Cumbria County Council with Eden District Council

The Councils' response to the Applicant's response to the Examining Authority's Issue Specific Hearing 2 Additional Questions

This document represents a table of responses to The Applicant’s [7.1] response to the Examining Authority’s Issue Specific Hearing 2 Additional Questions, document reference REP1-005. It has been prepared jointly by Cumbria County Council (“CCC”) and Eden District Council (“EDC”) together as the “the Councils” to set out further comments considered necessary in detailing the impacts upon the local area of National Highways’ (“NH”) proposed A66 Northern Trans-Pennine Project (“the Project”), which has been submitted for Development Consent. The Councils comments for Deadline 2 are entered in the right hand column and relate to the matters highlighted in yellow.

Drawing Number	Project	Originator	Volume
HE565627	- AMY	- HAC	-
S06	-DR-CH-	401300	
Location	Type	Role	Number

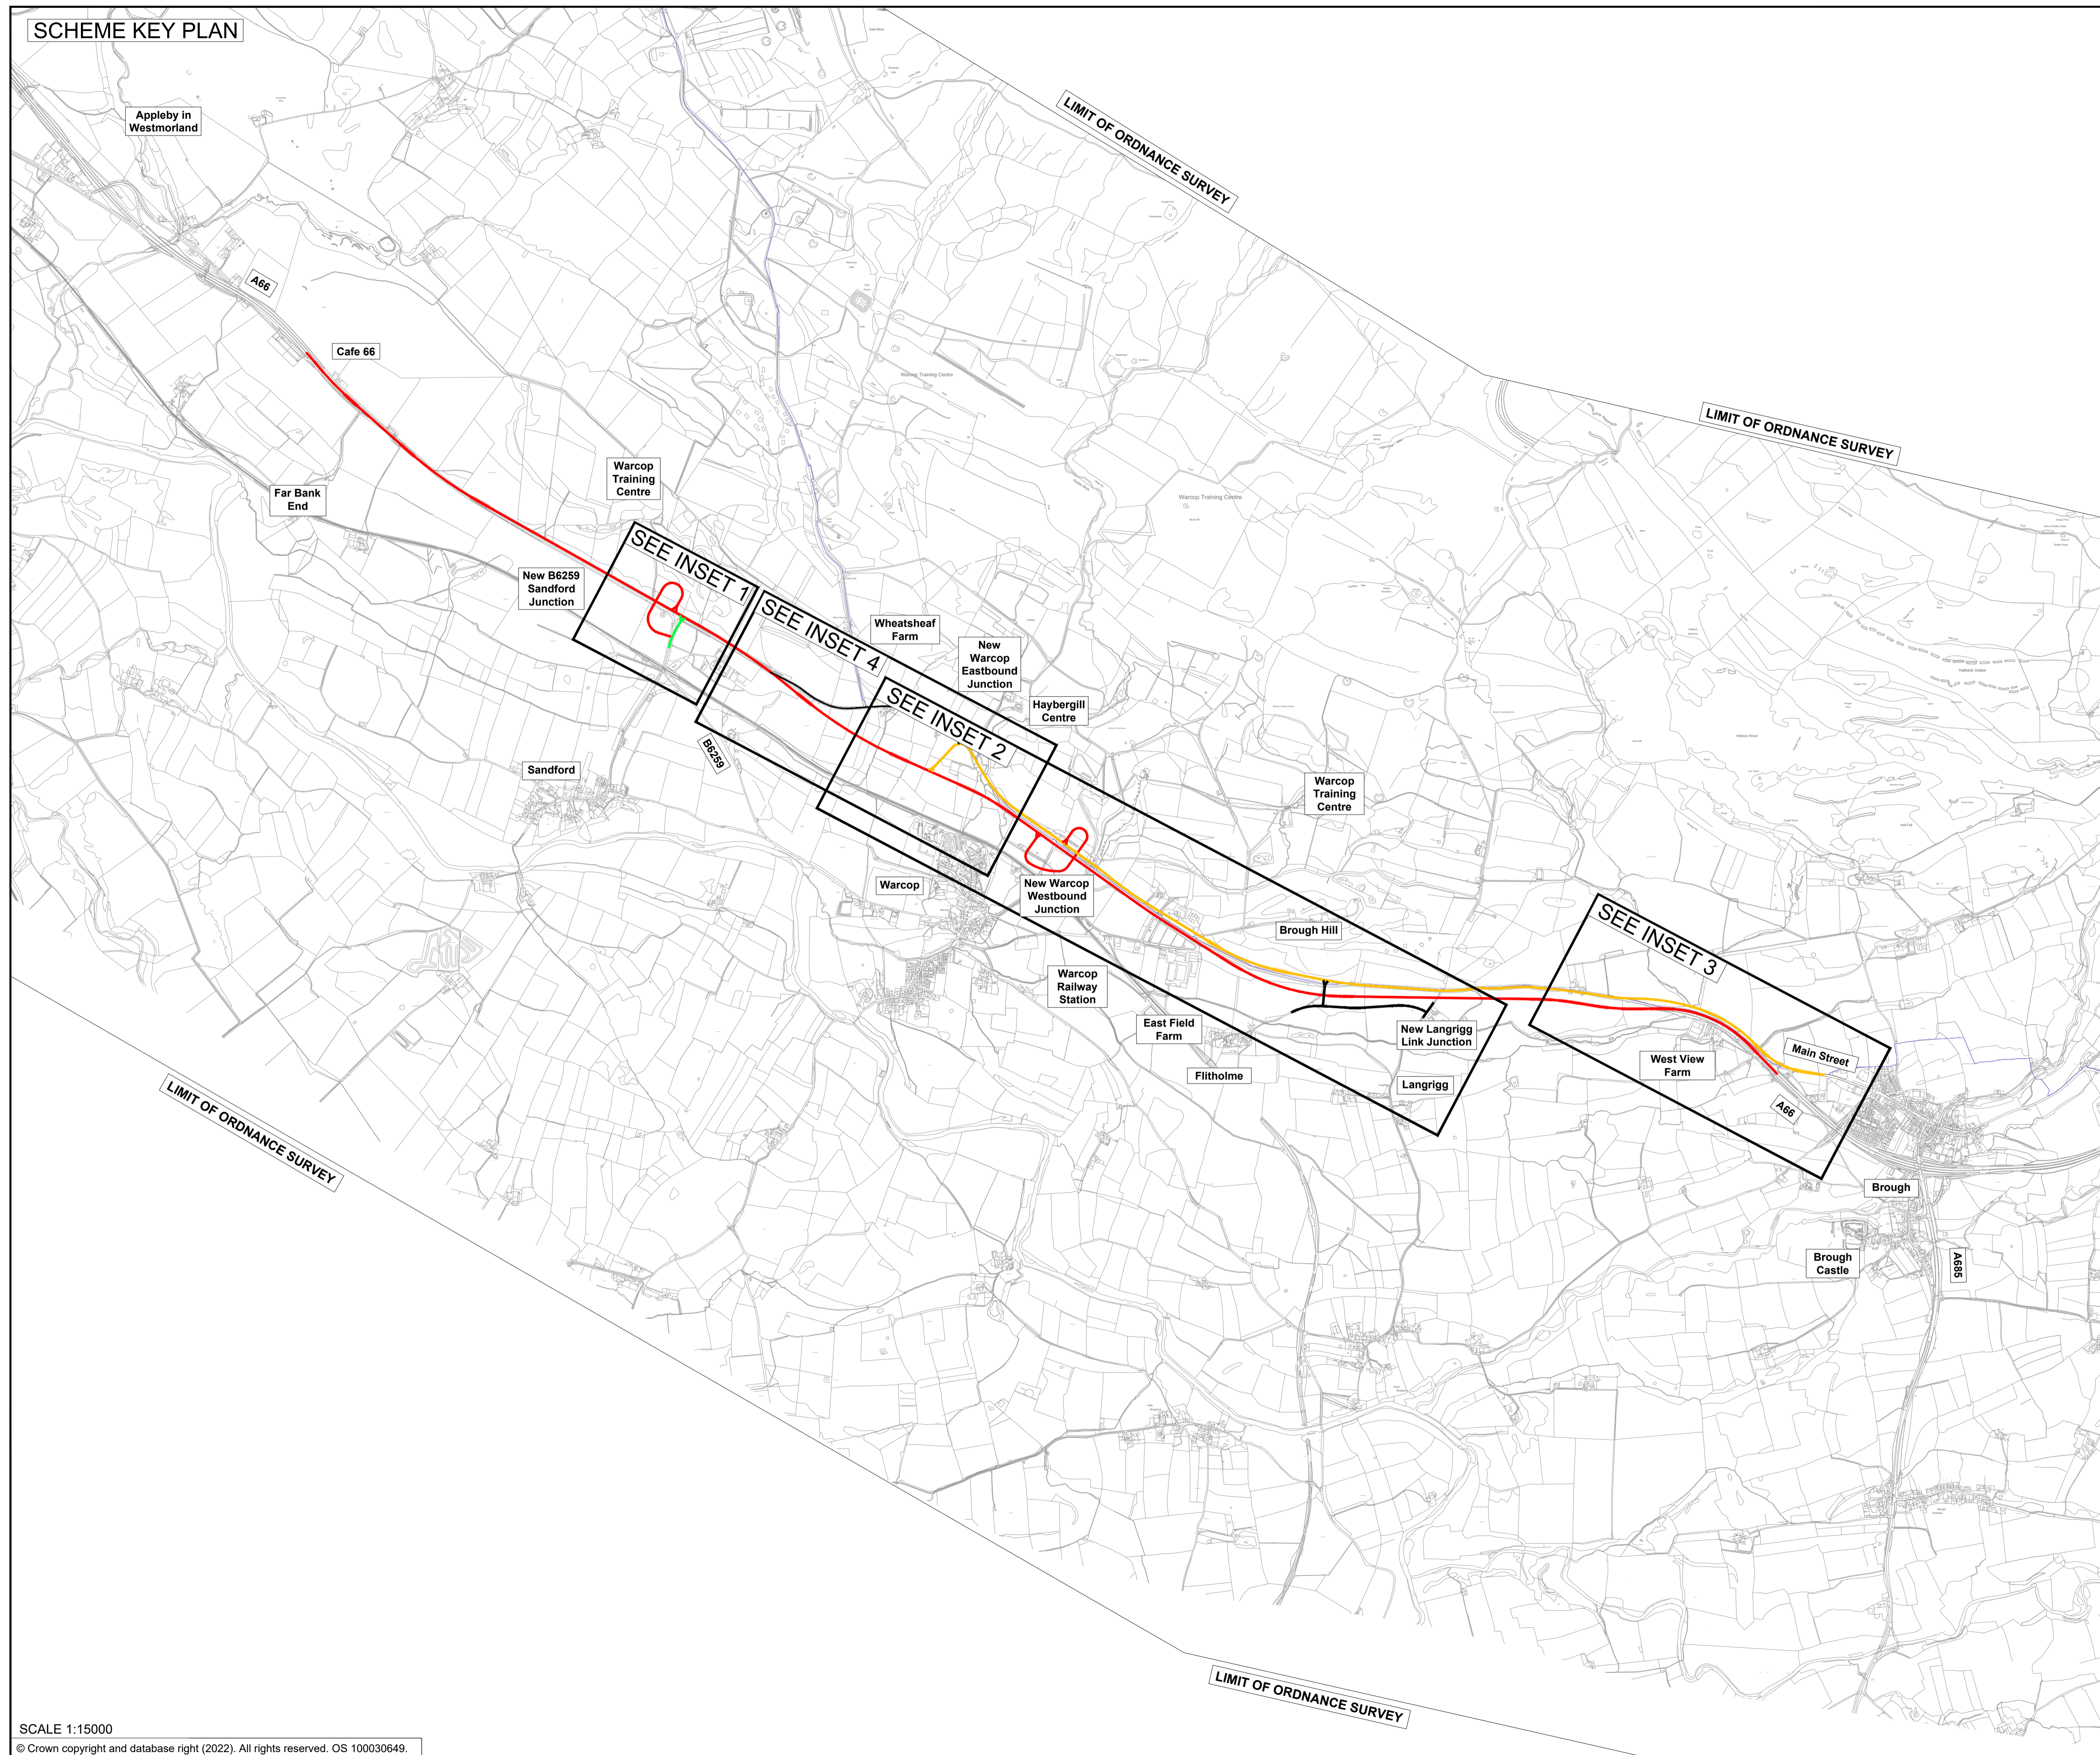
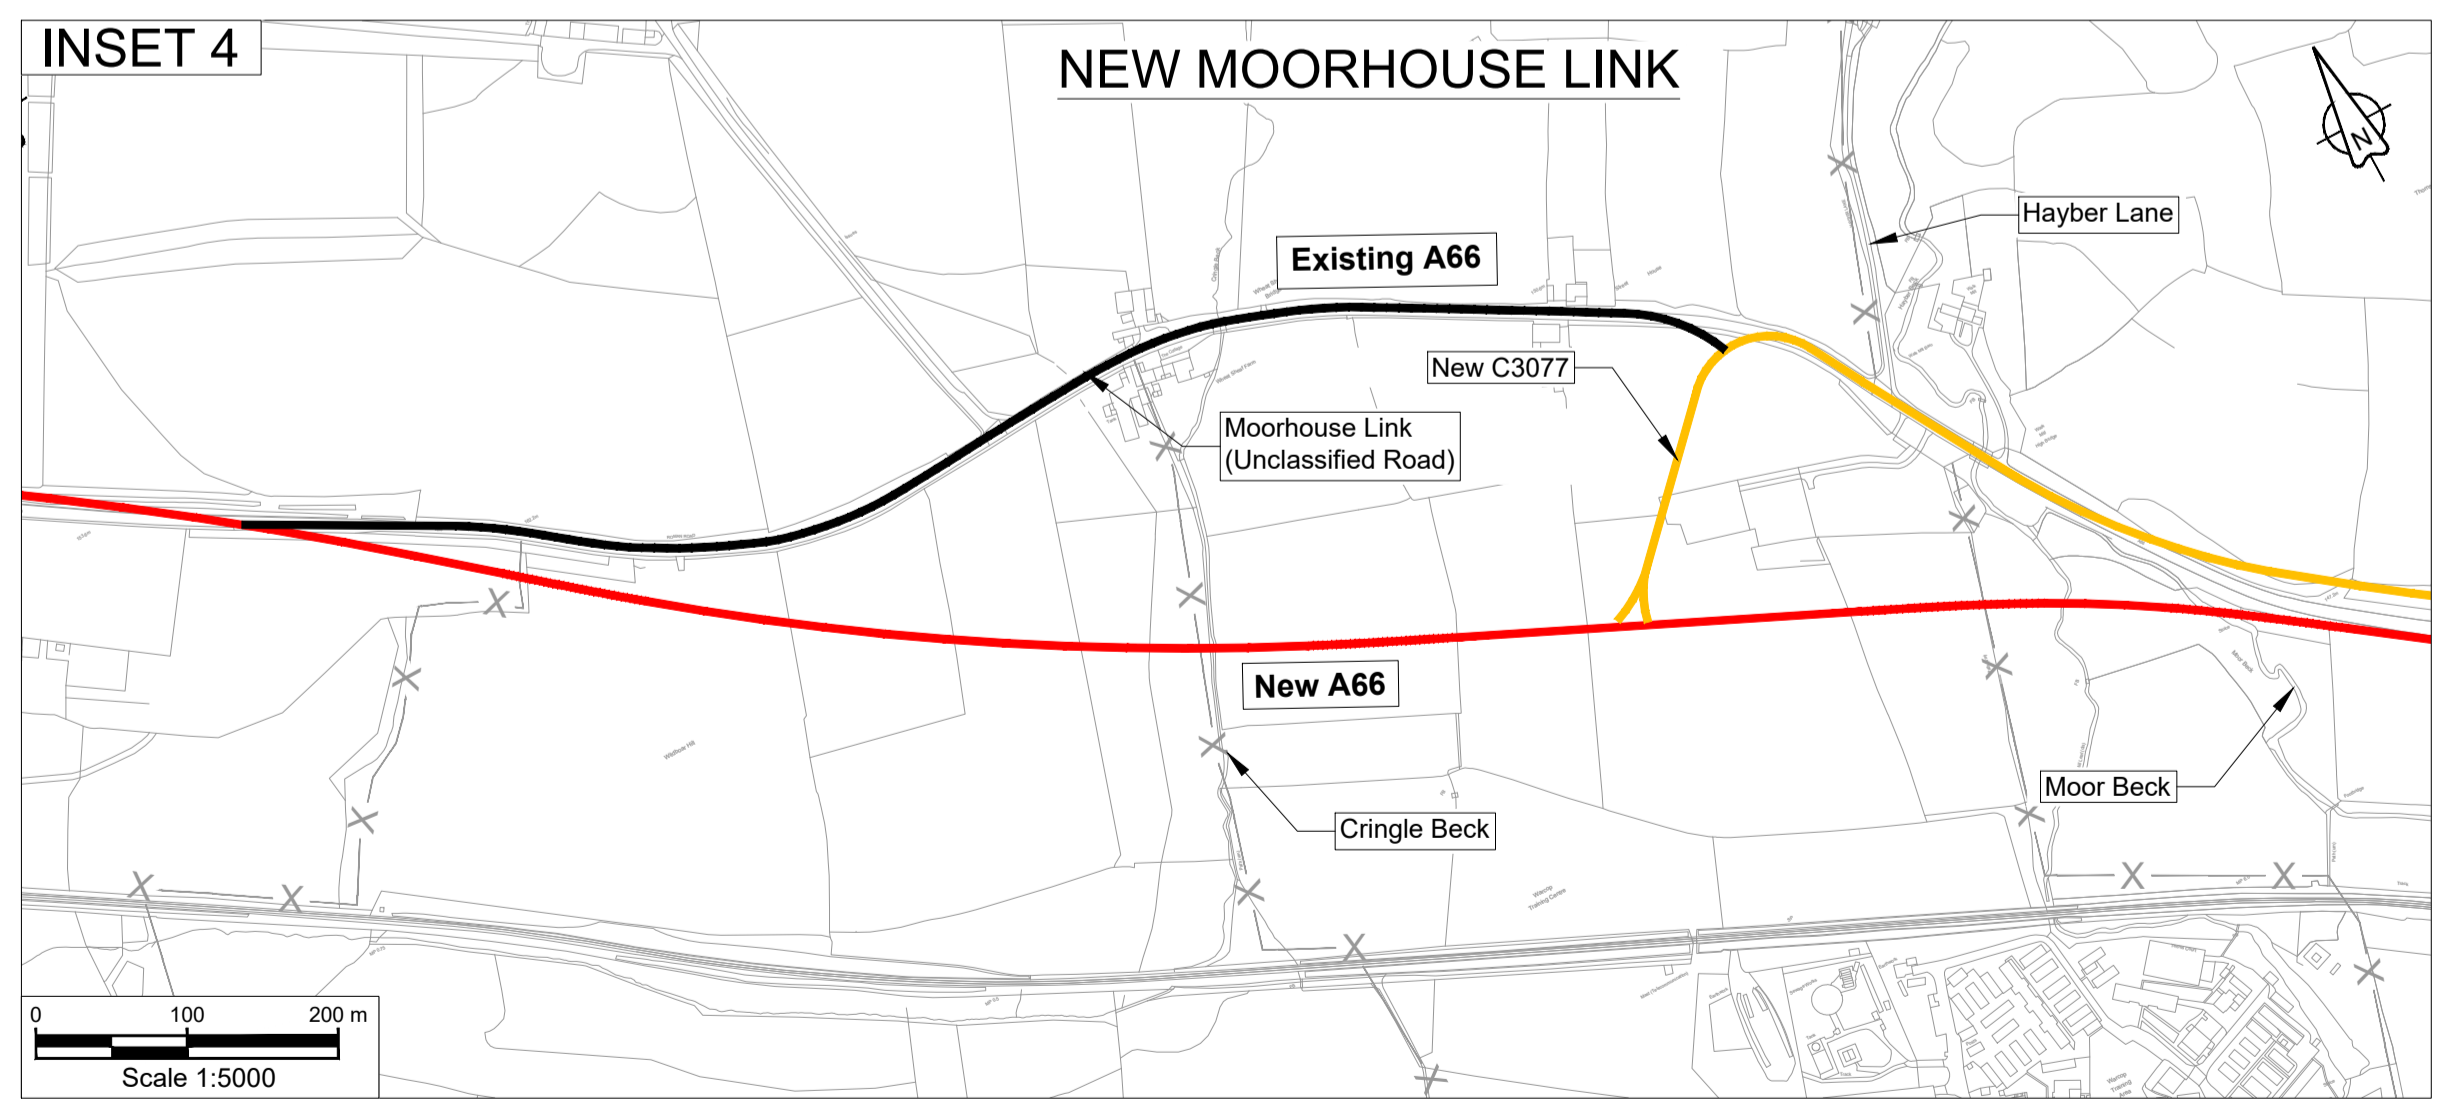
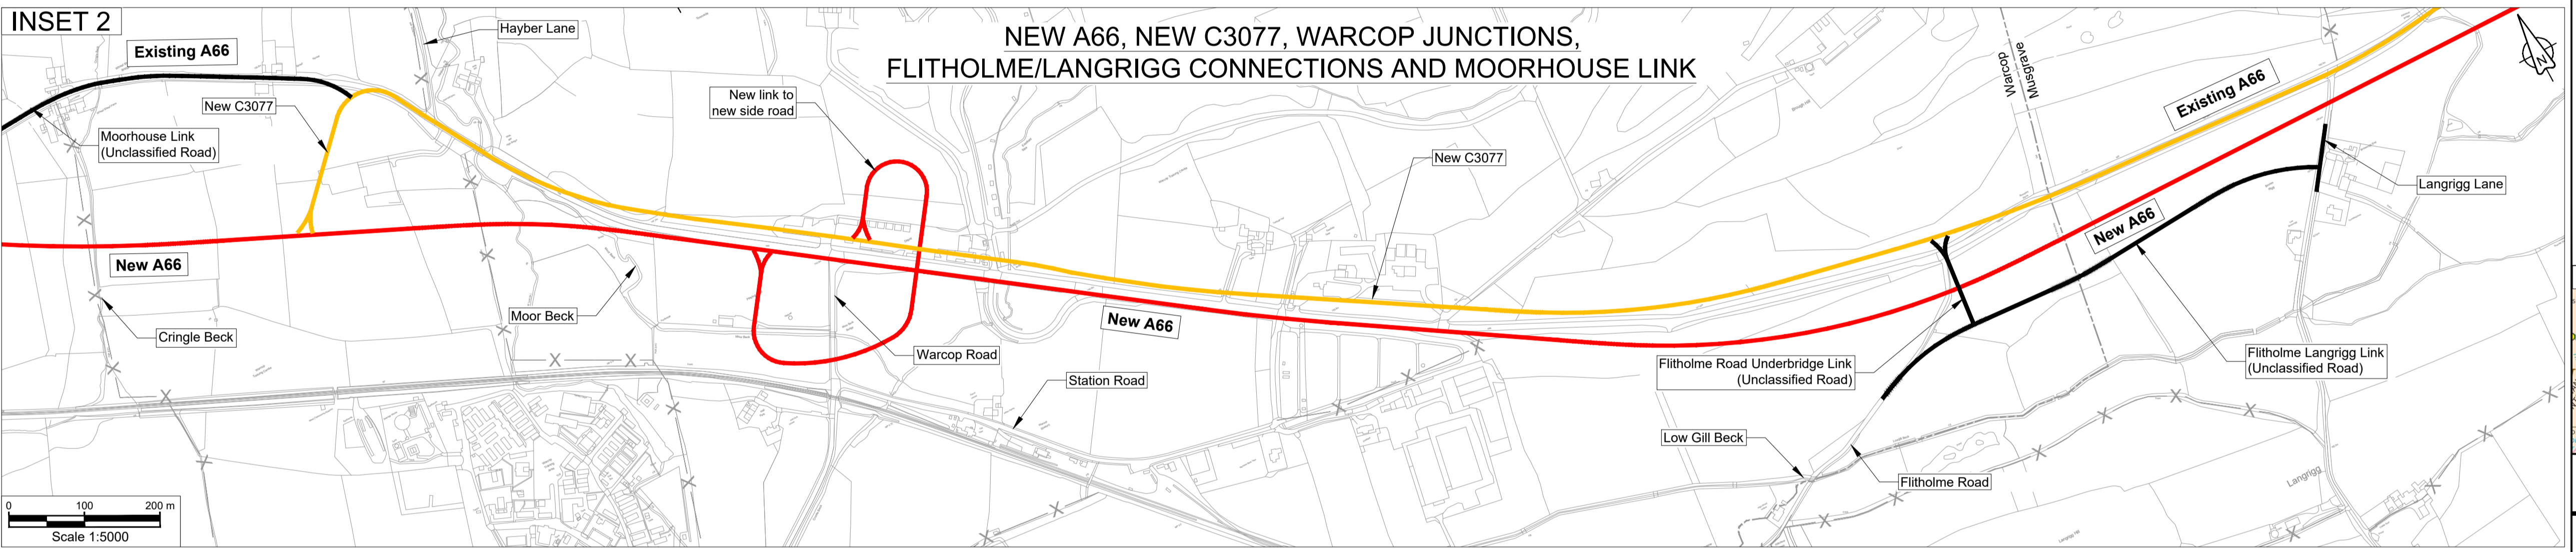
ISH2.DCO.19	Schedule 7 of the draft DCO, document reference APP-285	Applicant and Cumbria County Council (CCC)	Paragraph 56 (b) (p221-222 of Schedule 7 of the draft DCO document reference APP-285) sets out that the B1066 ends at "a point 254 metres west of the junction of Musgrave Lane and Main	CCC does not believe that the point indicated in Schedule 7 for the B1066 is a suitable point to start a classified road. CCC confirms that it would be more appropriate to	As noted in response to ISH2.DCO.18, the Applicant is reviewing the classification of roads provided for by paragraphs 55 and 56 of Schedule 7 to the draft DCO.	The Councils request that the highway authority be engaged in NH's review of the classification of roads provided for by paragraphs 55 and 56 of Schedule 7 to the draft DCO, particularly as the

Reference No	Subject	Response by	Question	Councils' Response to Issues Specific Hearing 2	Applicant's Response to ExA Written Questions	Councils' further comments (proposed / draft)
			Street". Confirm that this is that a suitable point to start a classified road on the unclassified Main Street. Confirm whether it would be more conventional to connect the new B1066 to the existing B6276 on Main Street at its junction with New Road.	connect to the existing junction on B6276.		Applicant intends CCC in its capacity as local Highway Authority (LHA) to adopt those roads.
POPULATION AND HEALTH						
ISH2.PH.03	ES Chapter 13 Population and Human Health (APP-056)	LPAs and LHAs	In respect to paragraph 13.5.3, confirm that the data used in the analysis of effects is robust given the lack of observed data available at the time of assessment.	The absence of any baseline data on WCH usage of PRoWs does present an issue in so far that the Applicant has not yet quantified the distance of each proposed diversion. Therefore, the Councils are being asked to comment upon the adequacy of PRoW diversions without having	LPA/LHA are being asked to respond on this, but the Applicant's position is set out below to assist the ExA: Currently active travel surveys are scheduled to be undertaken in spring 2023 once the better weather starts. These will be to inform detailed design, where applicable and time	The Councils would reiterate that their concerns set out under ISH2.PH.02, p9 of document reference REP1-018 around Public Rights of Way (PRoW) distances could be addressed through provision of a design and quantification of the duration and distance of
